**City of Portland, Maine - Building or Use Permit Application**  
 389 Congress Street, 04101 Tel: (207) 874-8703, Fax: (207) 874-8716

<b>Permit No:</b> 06-1341	<b>Issue Date:</b>	<b>CBL:</b> 083F A068001
------------------------------	--------------------	-----------------------------

<b>Past Use:</b> Vacant Land	<b>Proposed Use:</b> Single Family Home/ build a 2700 sq ft Single Family Home	<b>Permit Fee:</b> \$3,195.00	<b>Cost of Work:</b> \$310,000.00	<b>CEO District:</b> 1
<b>Proposed Project Description:</b> build a 2700 sq ft Single Family Home		<b>FIRE DEPT:</b> <input type="checkbox"/> Approved <input type="checkbox"/> Denied	<b>INSPECTION:</b> Use Group: Type	
		Signature:	Signature:	
<b>PEDESTRIAN ACTIVITIES DISTRICT (P.A.D.)</b>				
Action <input type="checkbox"/> Approved <input type="checkbox"/> Approved w/Condition <input type="checkbox"/> Denied				
Signature: Date:

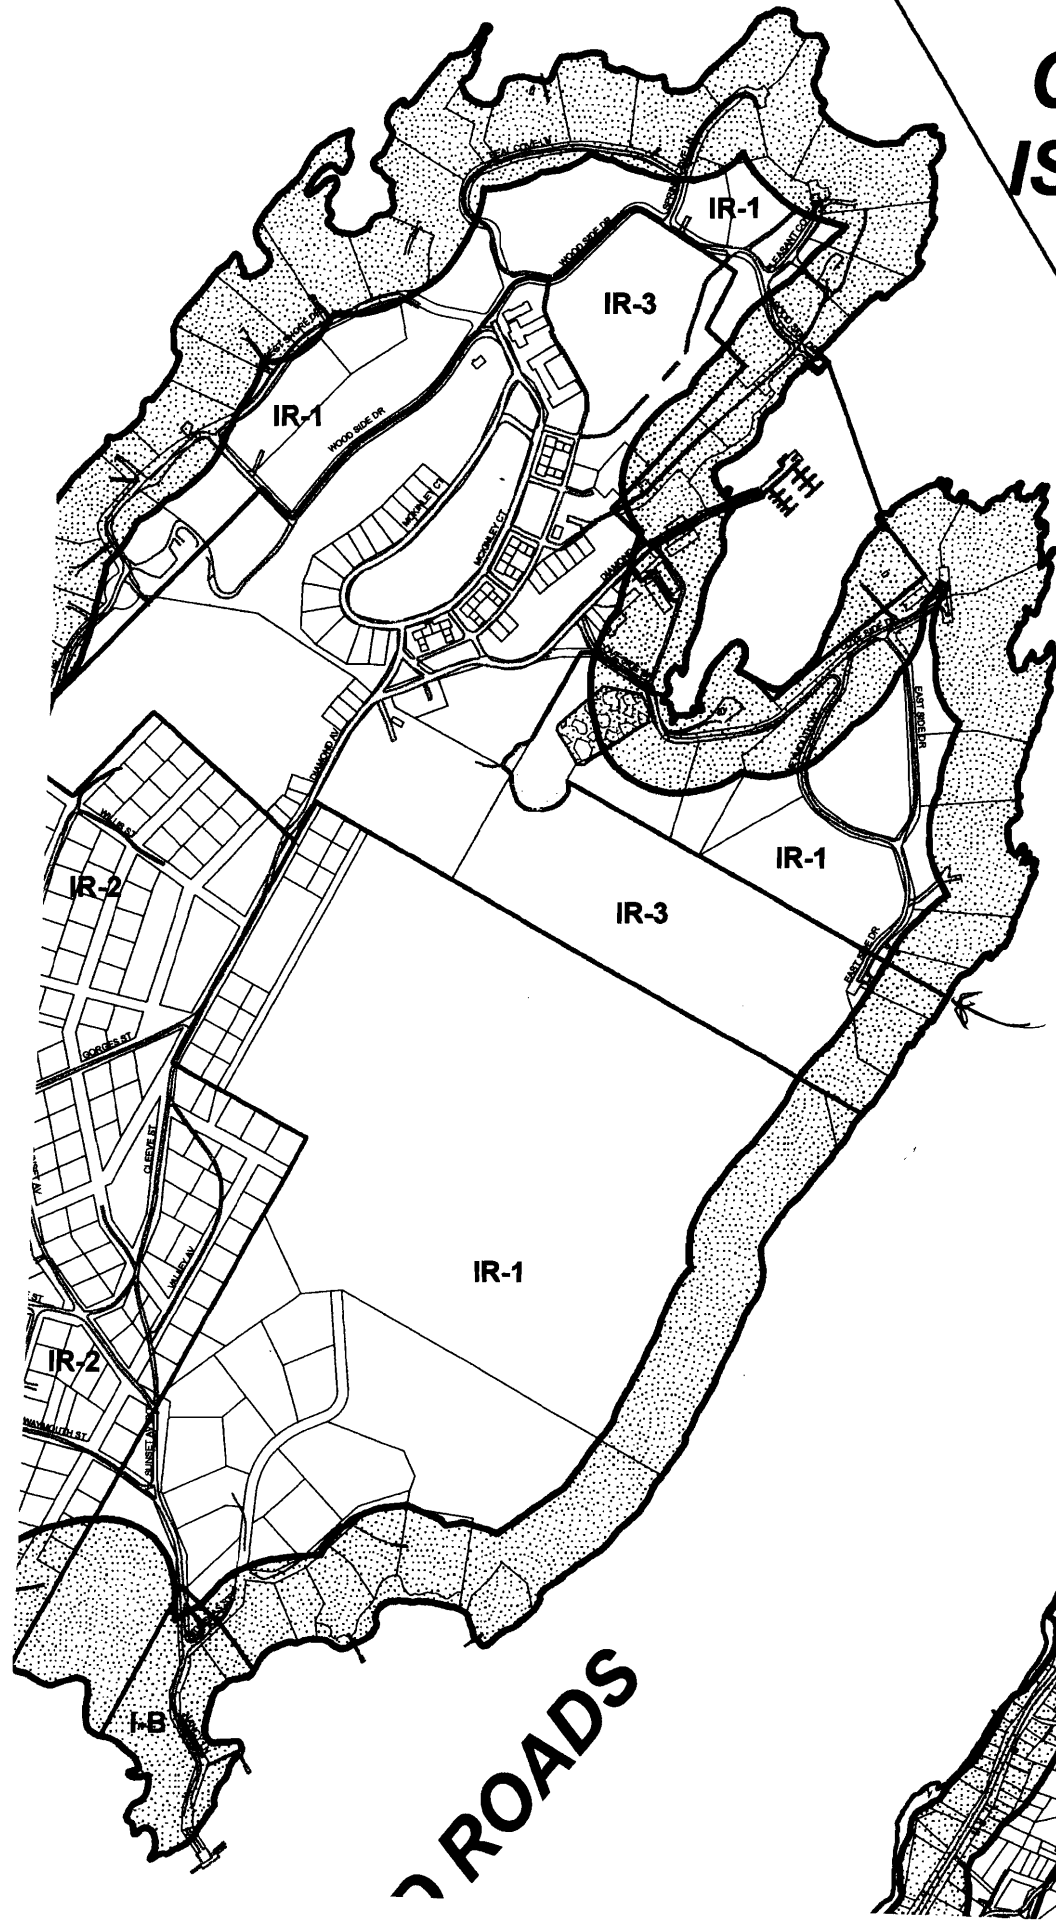
**Note:** Moving permit forward to plan reviewers. Still needs to show one more parking space. Zoning can't sign off **Ok to Issue:**  until we get this.

9/19/2006-amachado: Spoke to contractor, Deane MacBeth. Need 75' setback for shoreland on plan. Need footprint of structure on site plan to match footprint of building plans. Need to show two parking spaces. Need predevelopment grade on all four sides with elevations.

9/20/2006-amachado: Received revised site plan with 75' shoreland setback, but it needs to be done and stamped by a liscensed surveyor. I told Deane thsi and he will get one in. I still need elevations showing the grade on all sides of the building.

9/25/2006-gg: received revised site plan. /gg

1 WEST ELEVATION  
SCALE: 1/4" = 1'-0"

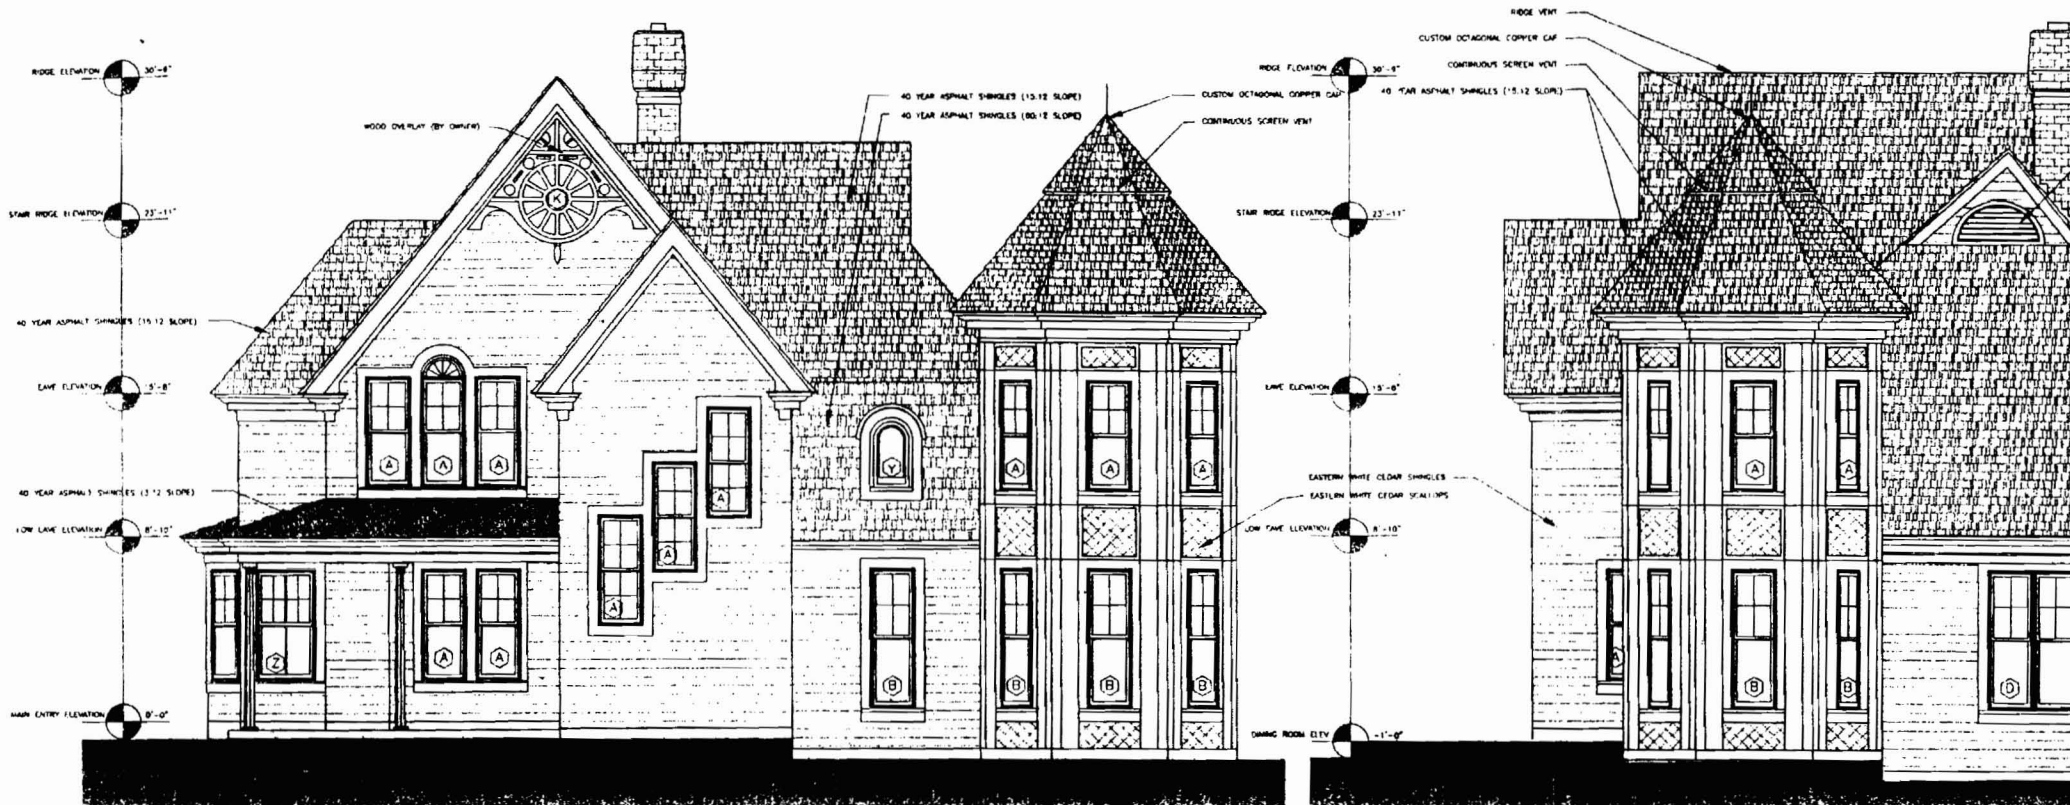
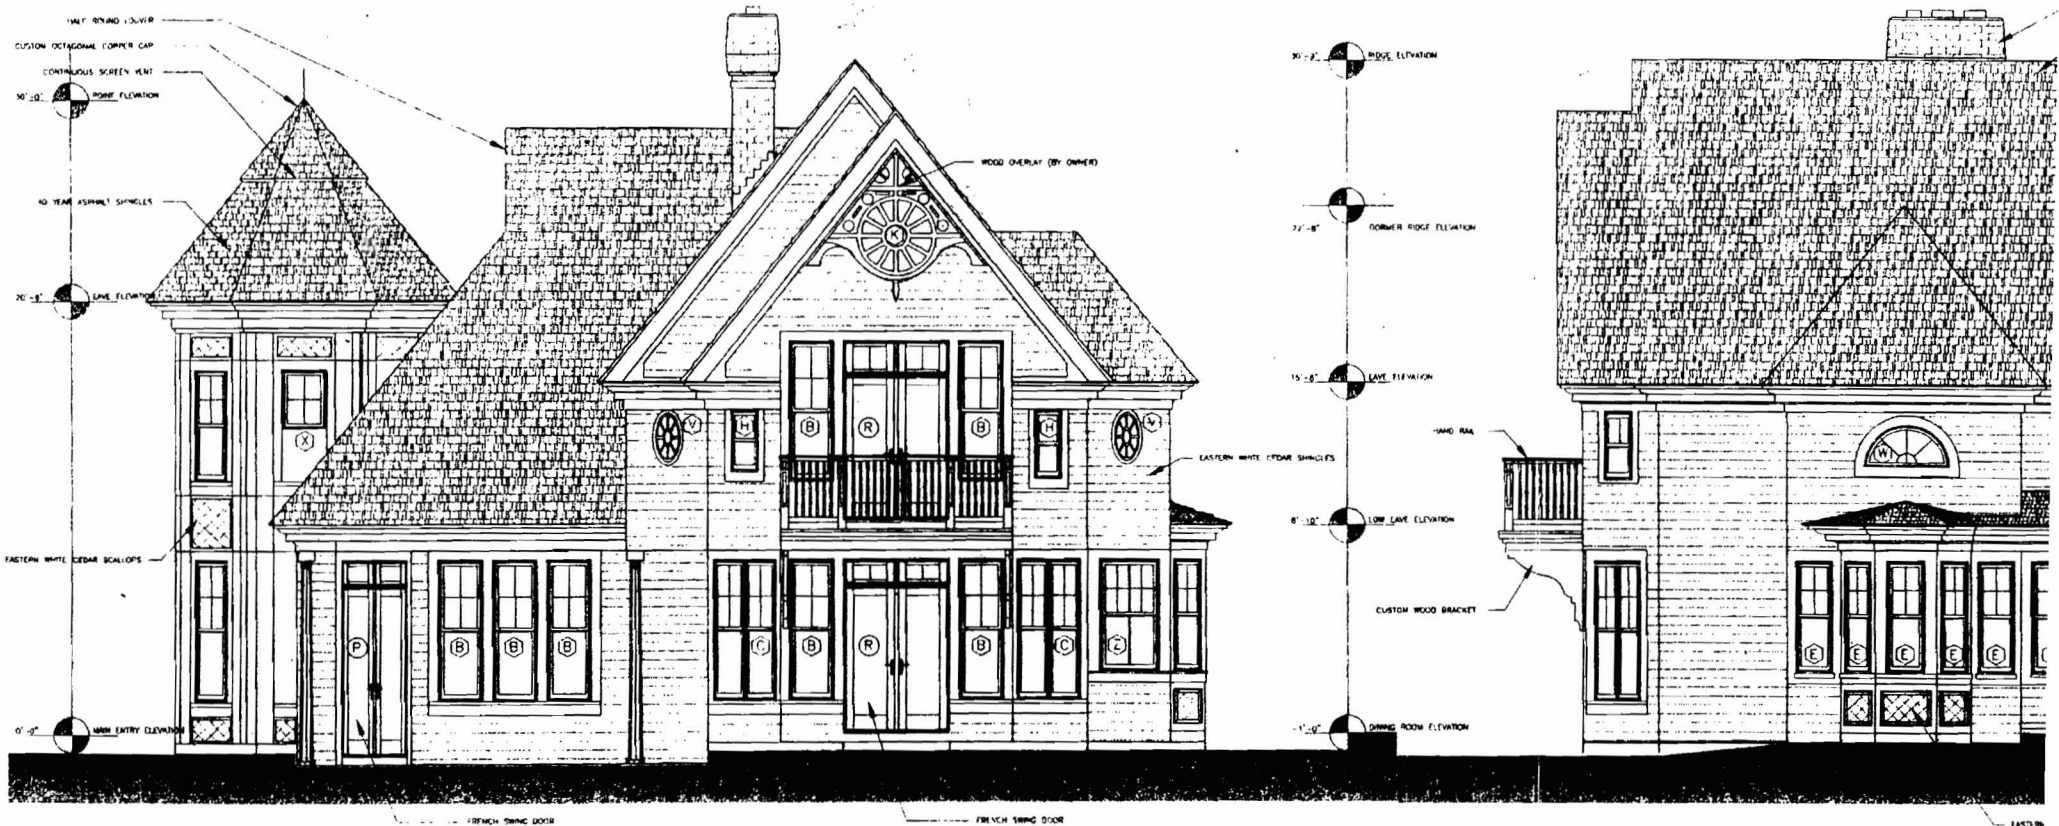
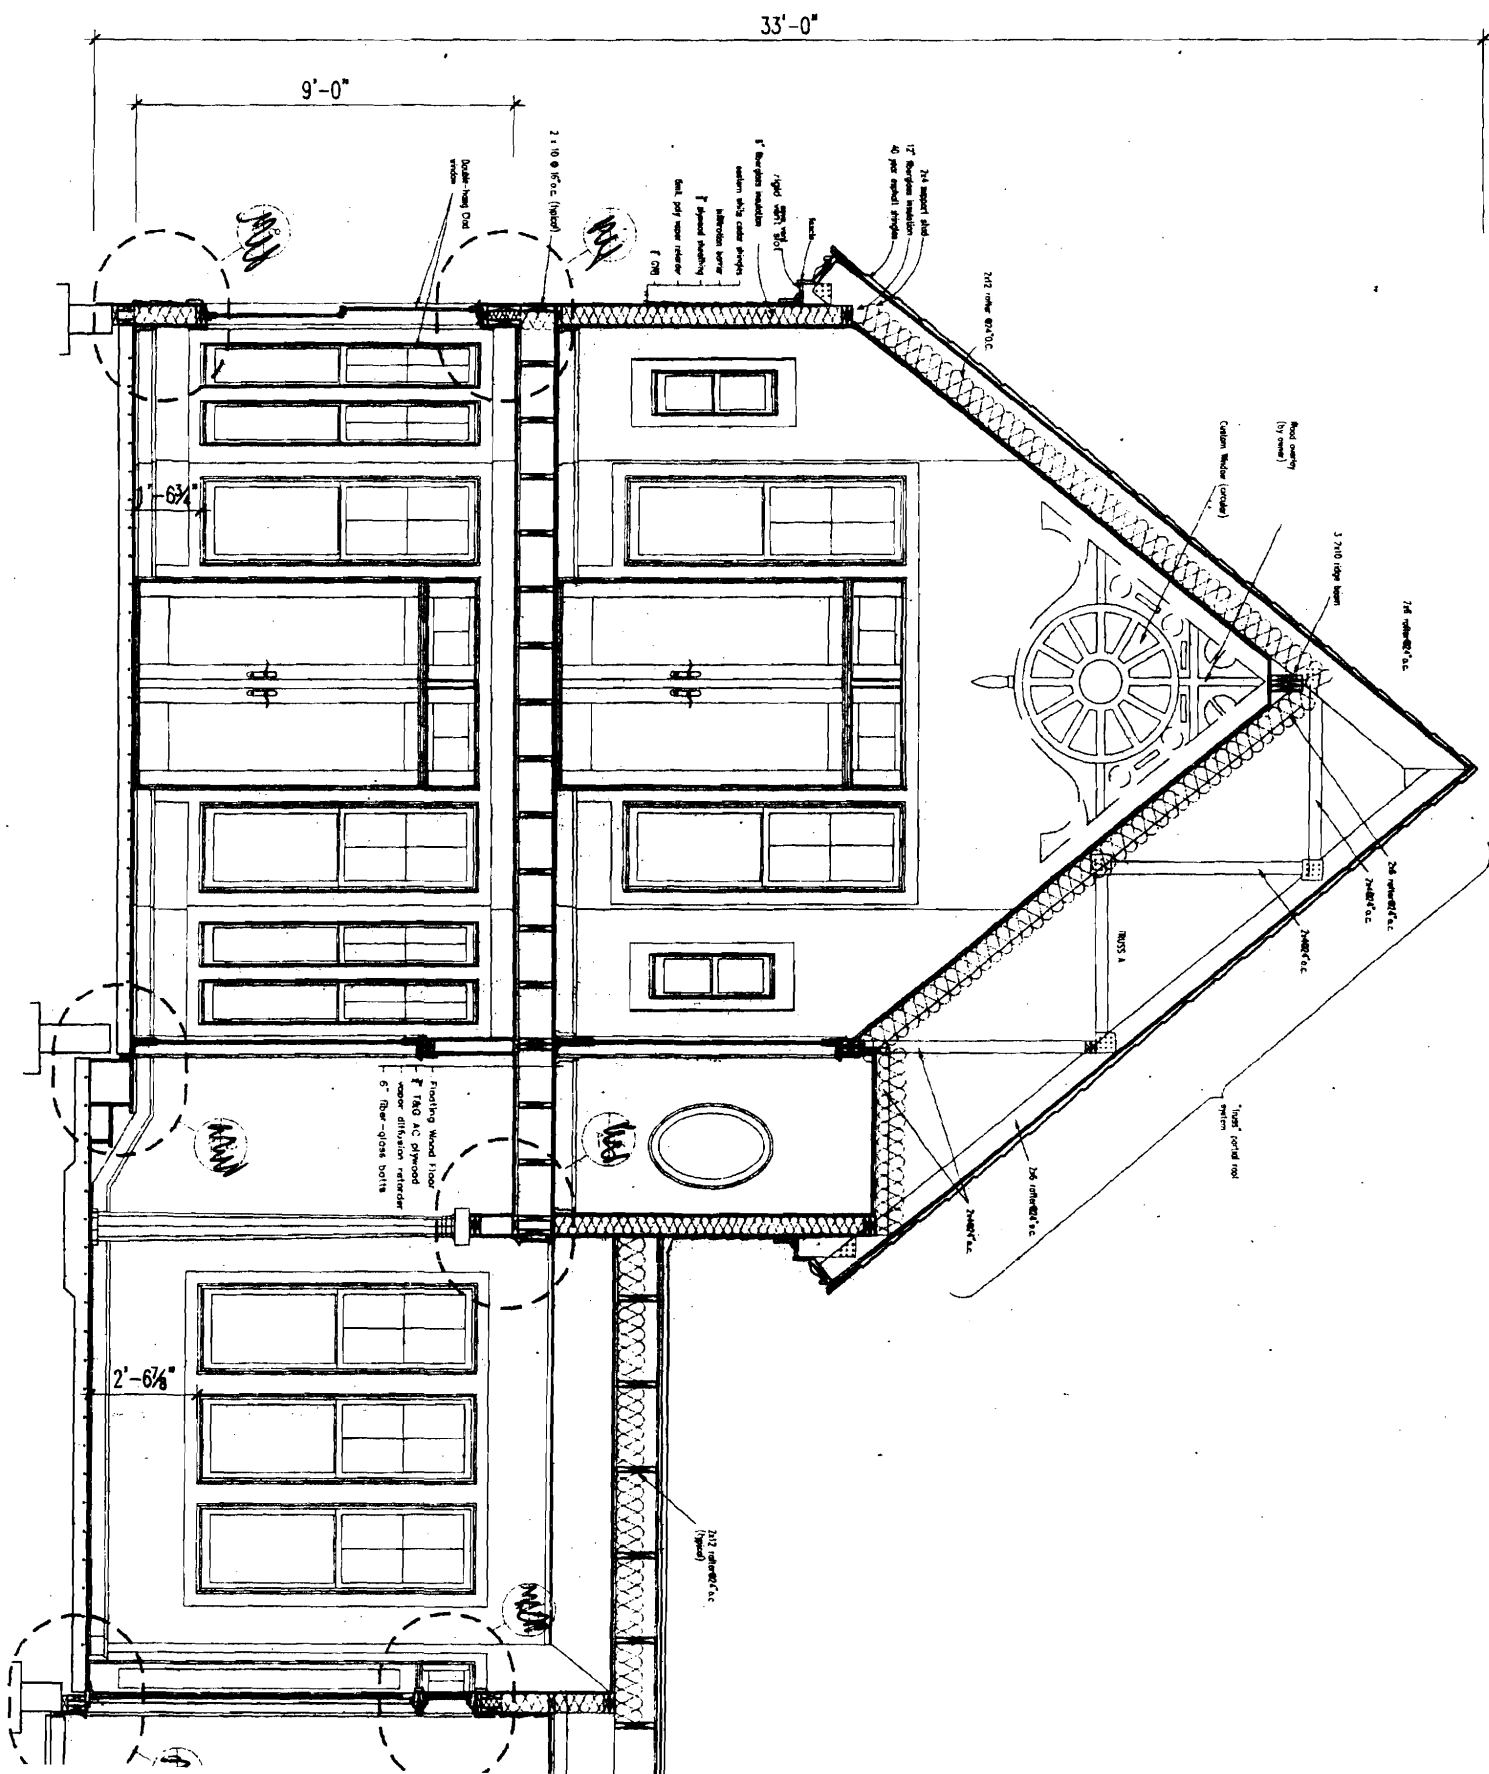
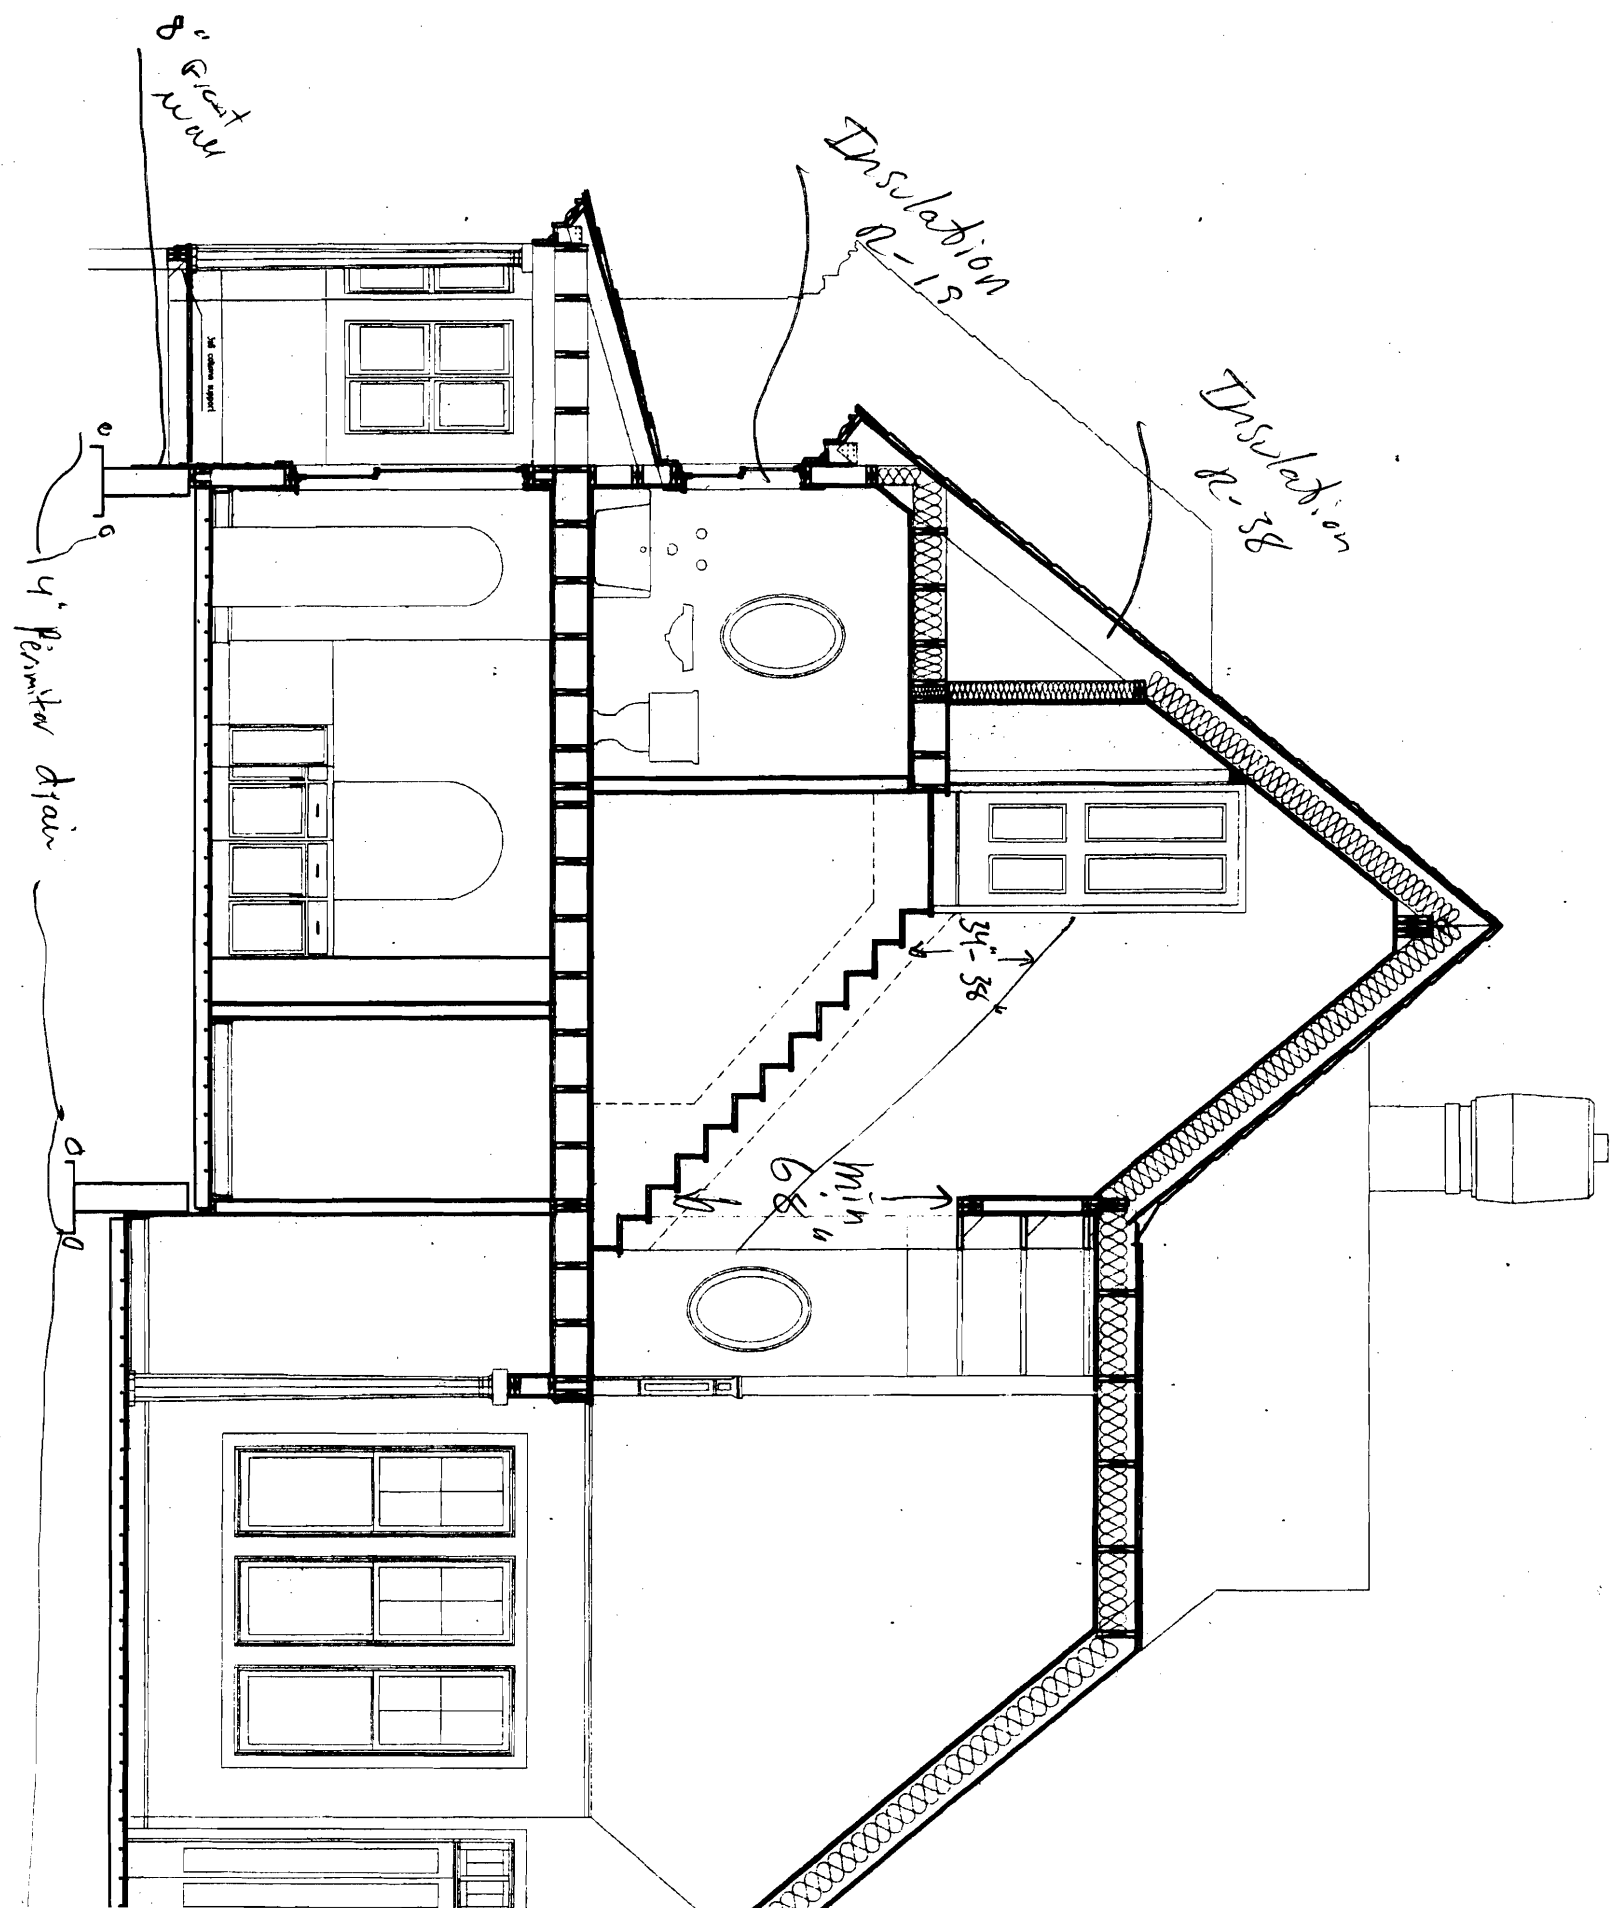
10/12/2006-amachado: Left message for Deane. Elevation plans dropped off yesterday, but they still don't show where pre construction grade is compared to the house so I can scale the height of the house. Also I need a scalable site plan that shows the 75' setback and two parking spaces.
